20 December 2021

TfNSW Reference: SYD21/00981/03

Departments Reference: SSD-25725029

**EXHIBITION OF EIS – ARDEX WAREHOUSE & MANUFACTURING FACILITY –
657-769 MAMRE ROAD - KEMPS CREEK**

Appendix D. Swept Path Analysis and Design Commentary

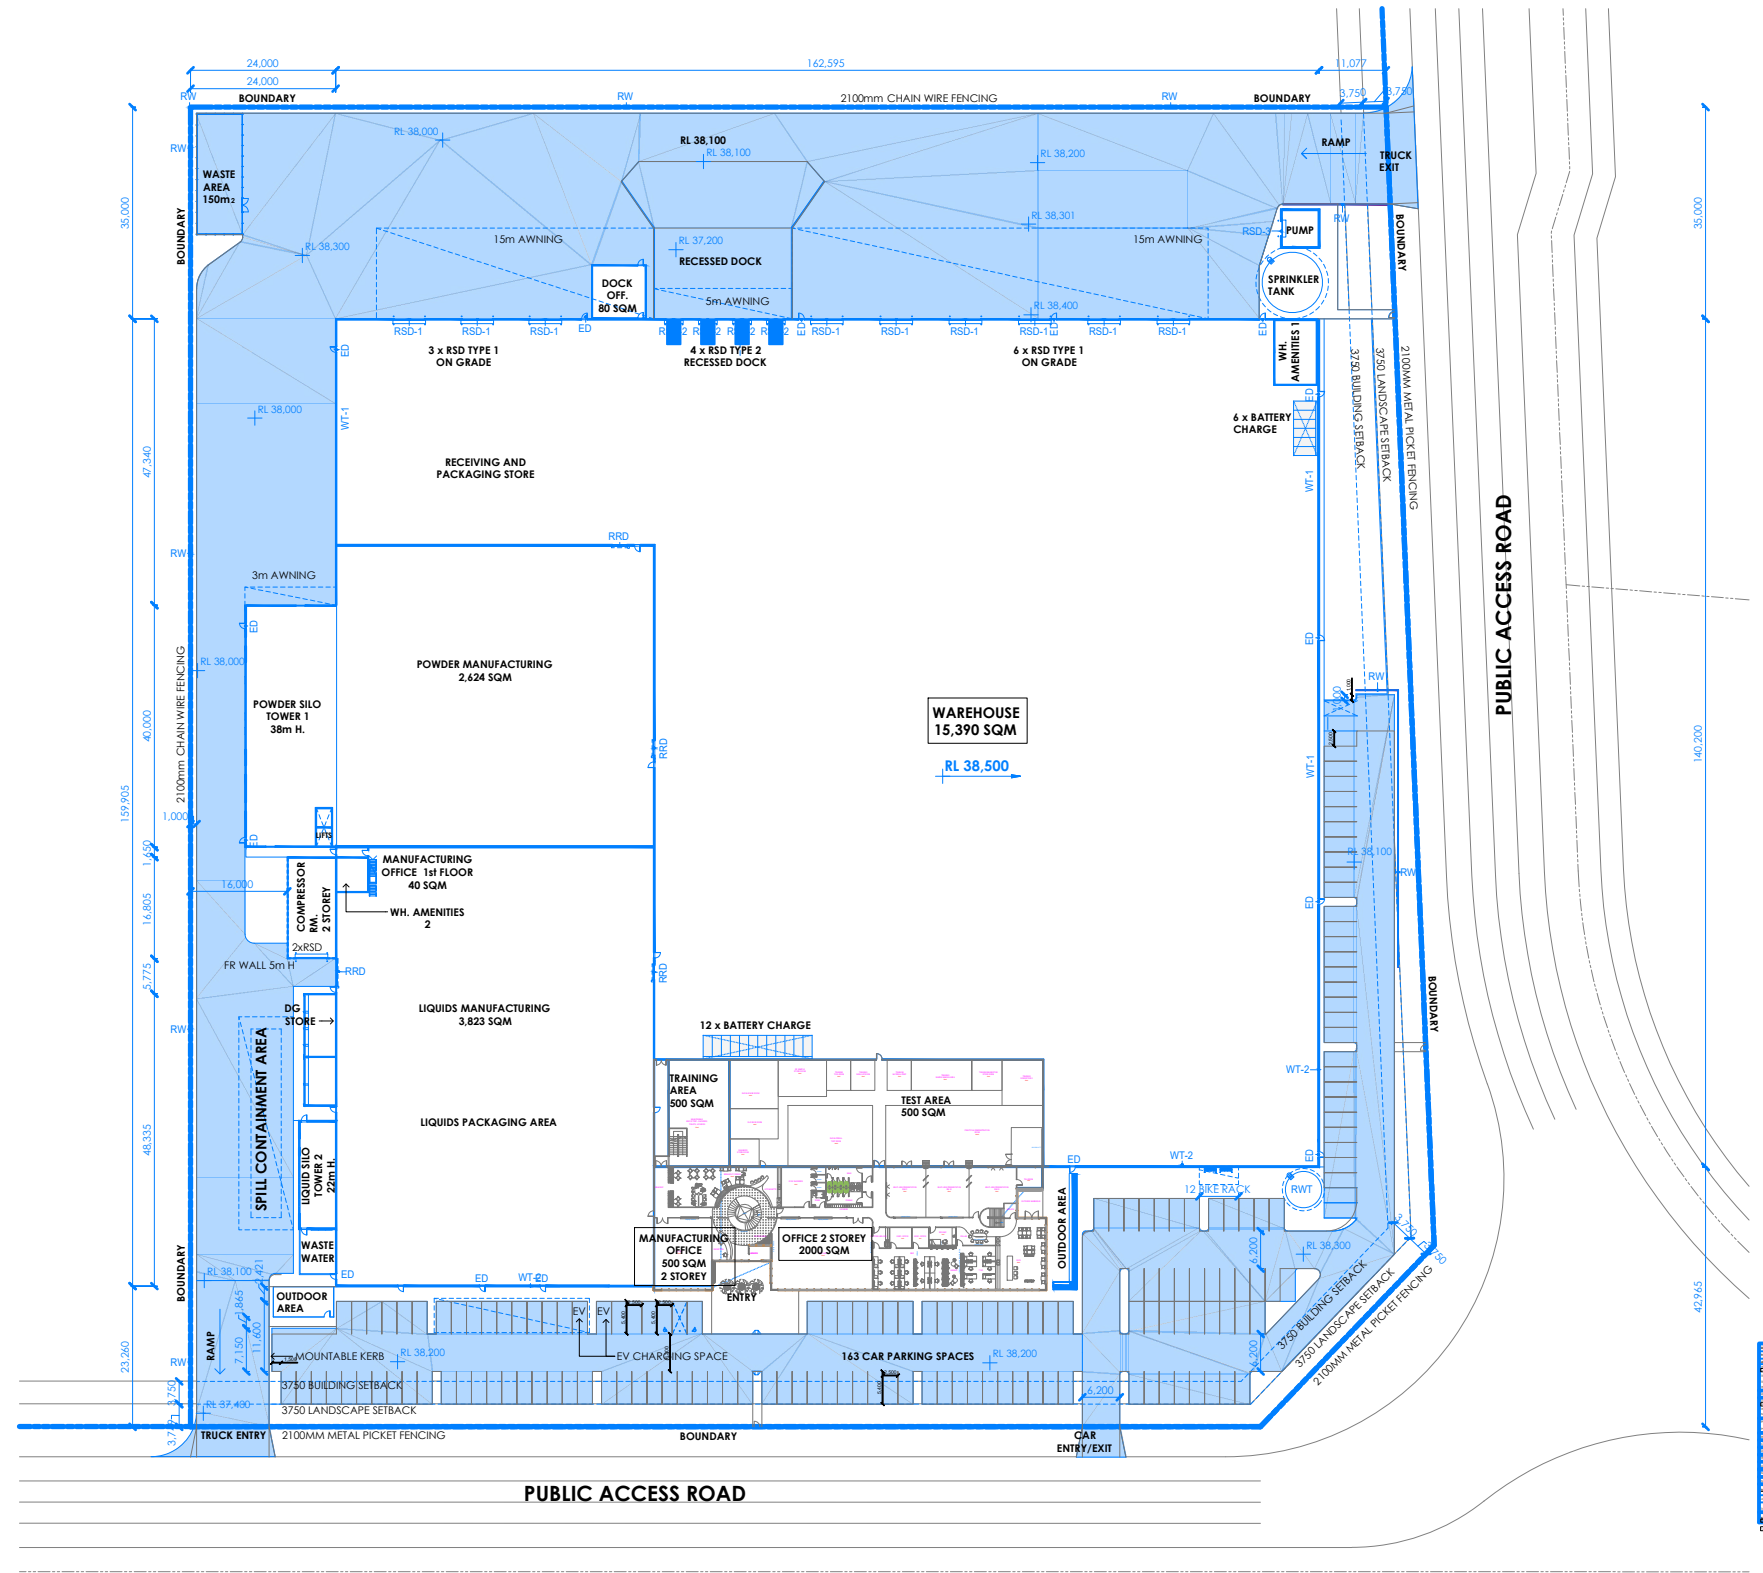
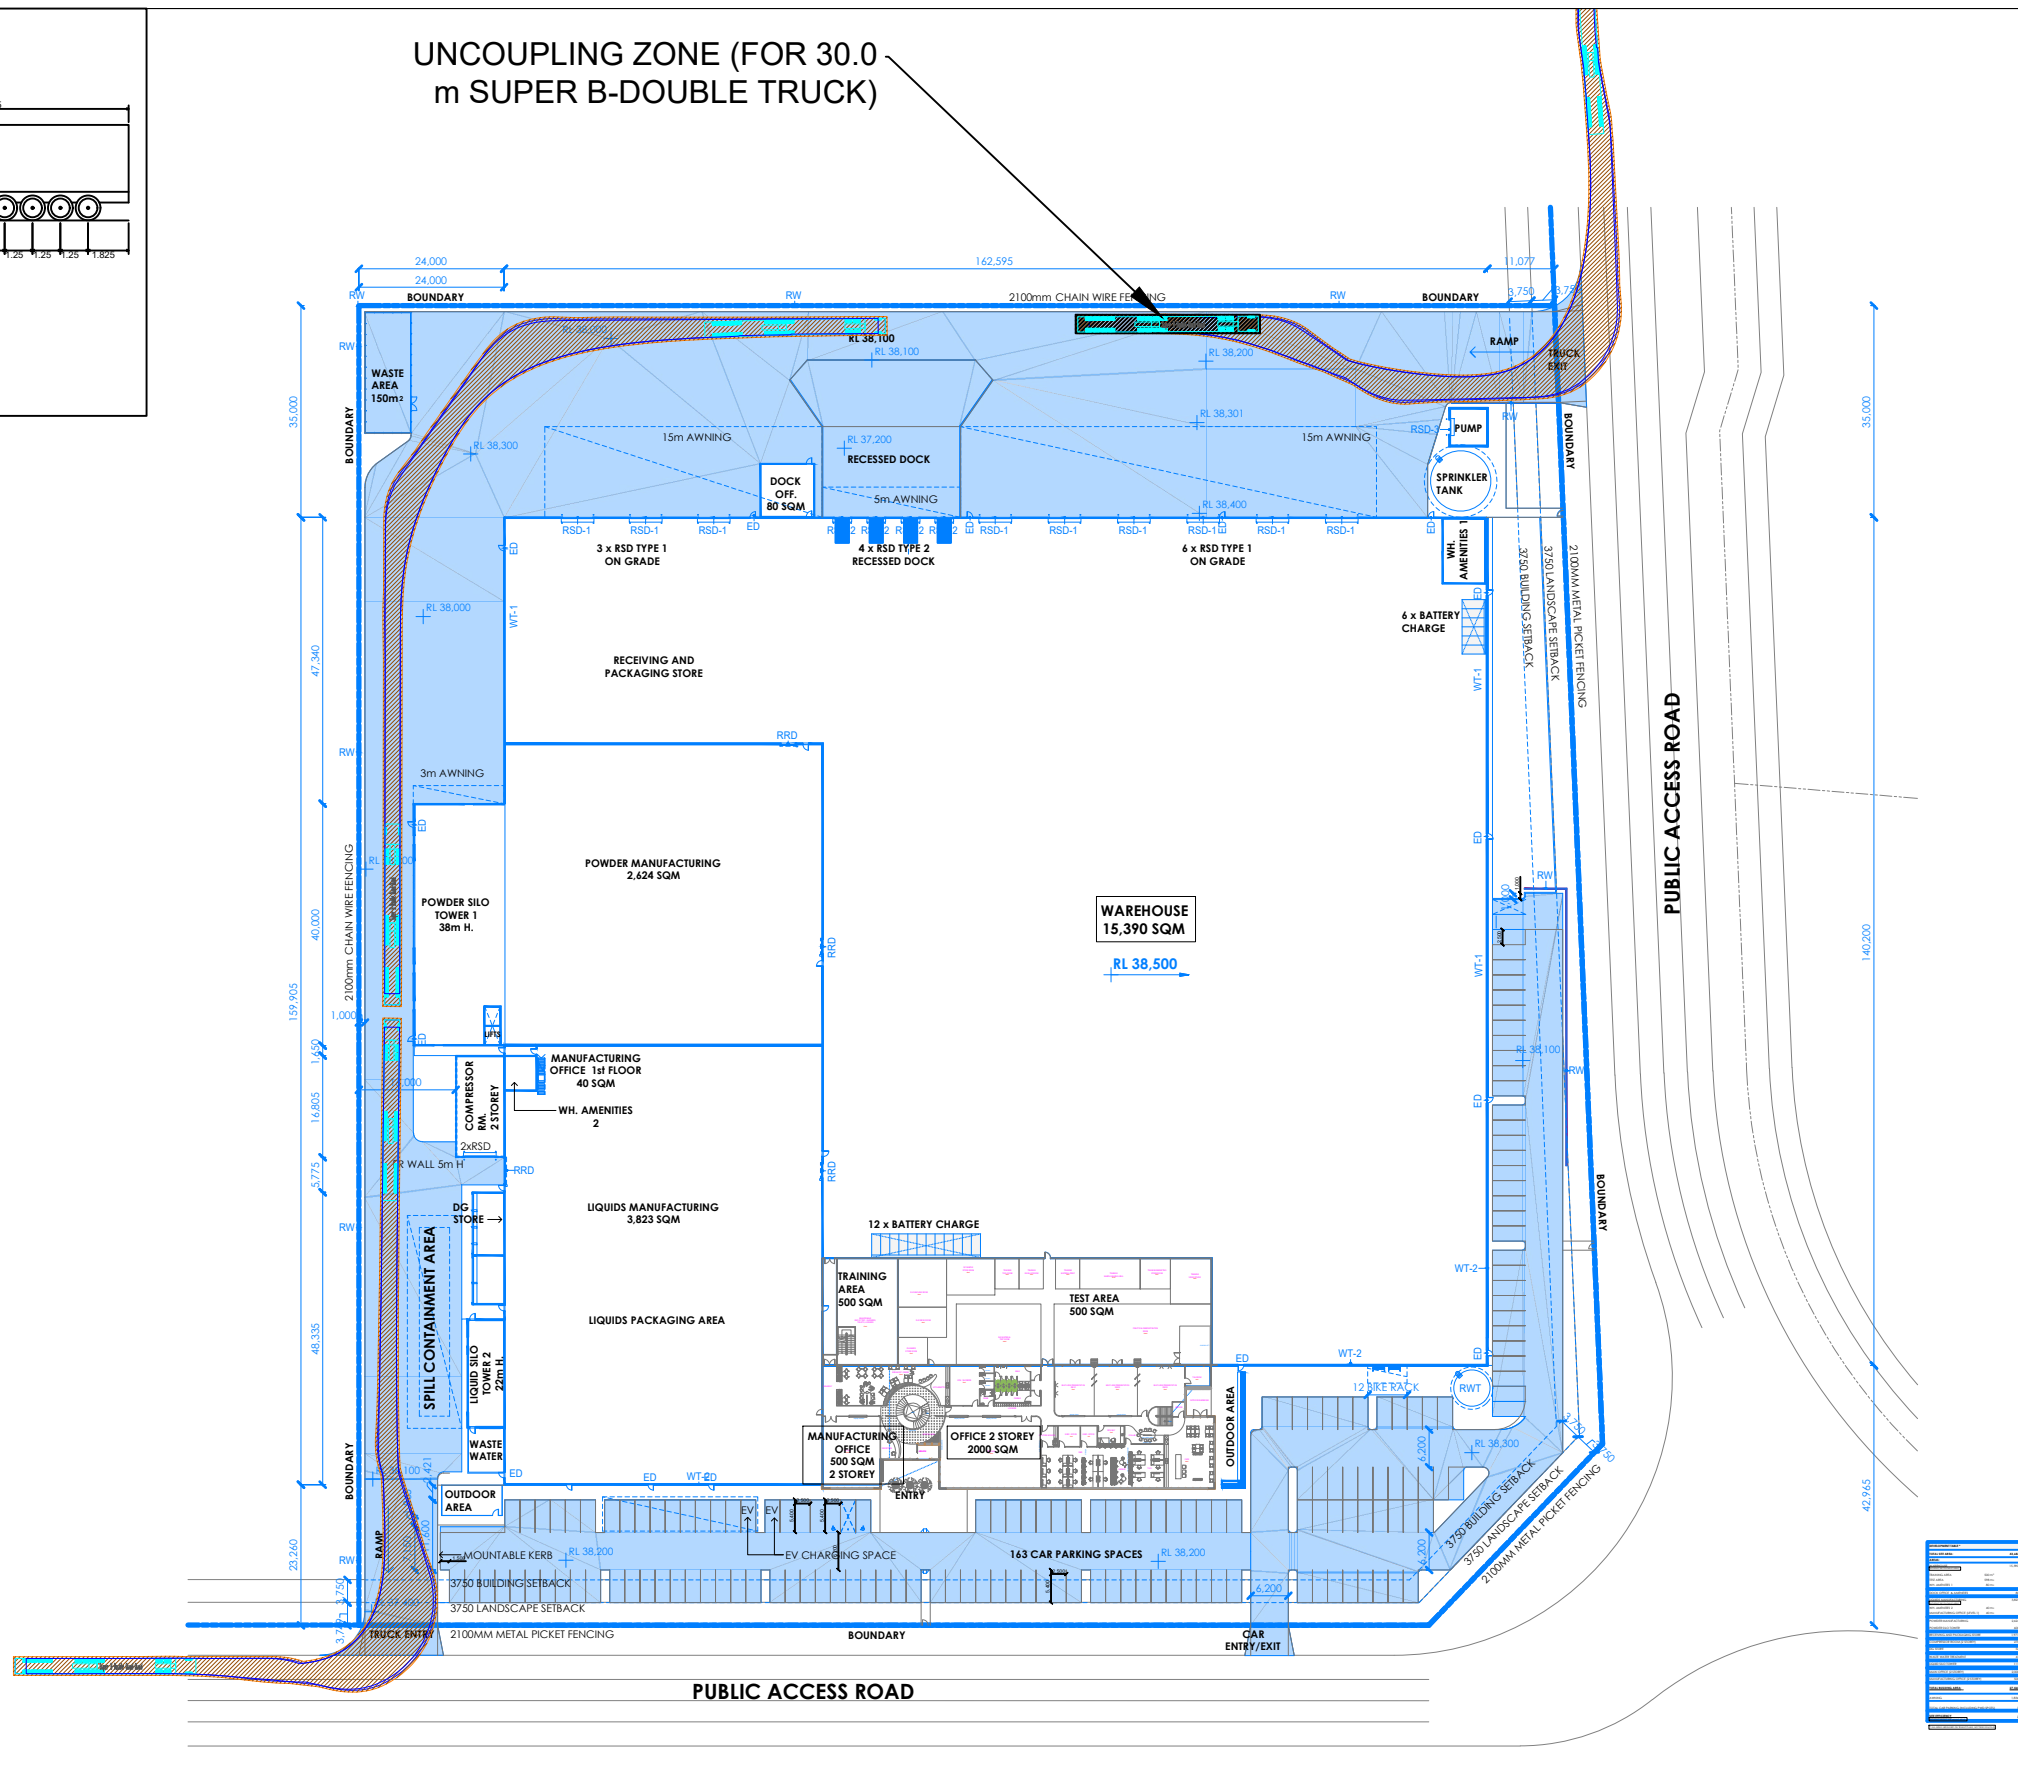
Appendix D – *Swept Path Analysis and Design Commentary* – The swept path plans are provided for 26m A-Double. According to the Mamre Road Precinct DCP Road design item (20), it should be tested for 36m PBS Level 3 type A vehicles.

It is requested that Swept path plans be provided showing the test vehicle of a 36m PBS Level 3 type A vehicle.
